## *Rezoning Petition Review*

**Rezoning Petition #:** 08-147

**Location of Property:** Approximately 12.17 acres located on the north side of Brookshire Blvd. between Oakdale Rd and Caldwell Williams Rd

1 SITE LAYOUT & PAVING PLAN
C-1
Scale: 1" = 60'

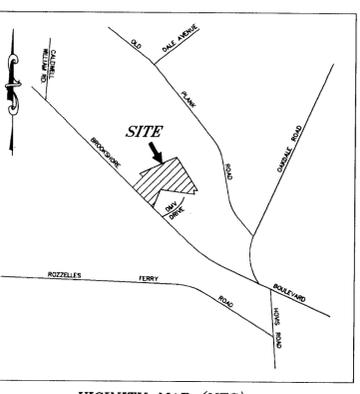
**Recommendations Concerning Storm Water:** **Please remove Storm Water notes and replace with the following note:**

The petitioner shall comply with the Charlotte City Council approved and adopted Post Construction Controls Ordinance.
